RE: Eastside Renovation of Kennel D Canine Facilities

8920 Lomas Blvd.

Hydrology File: K20D015

The following items require correction or additional verification prior to engineer's final certification for Permanent Certification of Occupancy:

GRADING & DRAINAGE PLAN

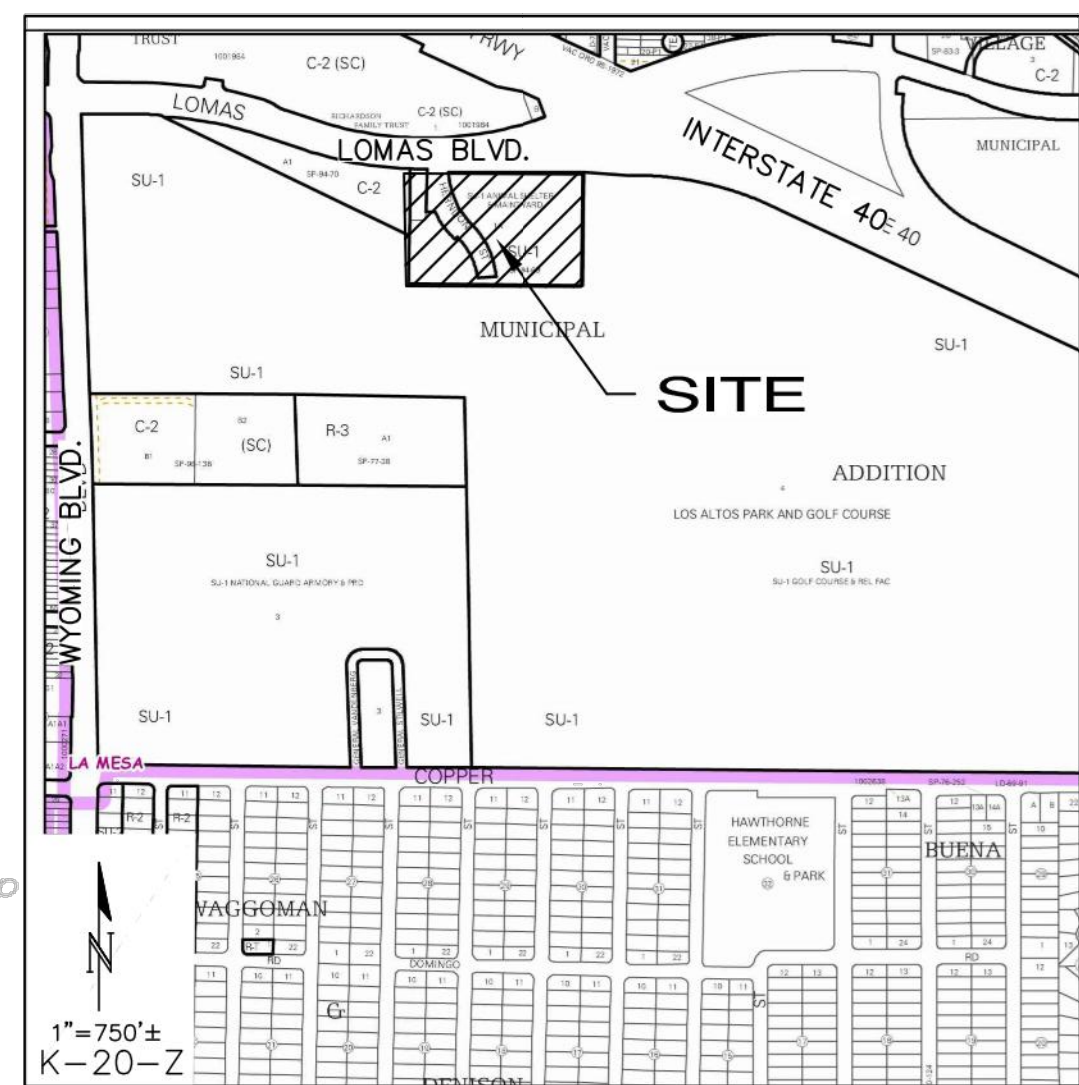
• The Rip-Rap swale north of the building must be completed.
